Erection of 1.82m brick wall to replace existing hedge along site northern boundary, with vehicular & pedestrian access points

Preston House Seafield Road East Preston

Thank you for your internet representation made on 4th July 2018 which has been recorded as '**an objection**' with the comments as follows:

DESCRIPTION	CLIENT	PROJECT	SITE ADDRESS	PROJECT NO.	ISSUE	DRAWN BY	DRAWING NO.	SCALE	REV A SHEET 2
Existing and Proposed Elevations	Mr Patrice Najbor	New Front Boundary Wall	Preston House, Seafield Road East Preston, BN16 1NA	9180328	24.04.2018	DAM	9180328-RS-GA-01-02	1:200 @ A3

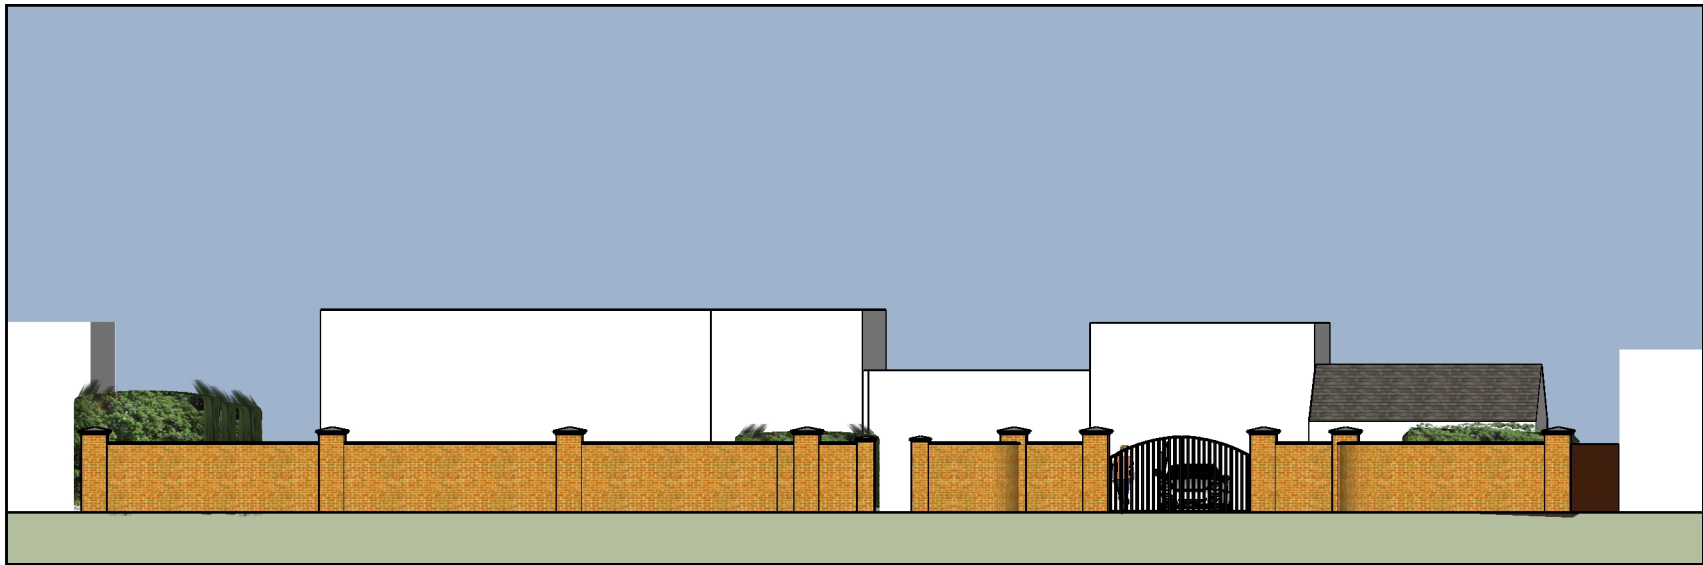
Preston House has the longest frontage in Seafield Road. Its hedge therefore makes a major contribution to the present character of the road and the attractive, informal, streetscape. The replacement of this hedge by a 1.82 metre tall brick wall would significantly alter the appearance of the road, rendering it more formal and less attractive.

Constructing such a wall would weaken the character that justified the designation of Seafield Road as an Area of Special Character. The amenities of the area would be diminished. It should not therefore be permitted.
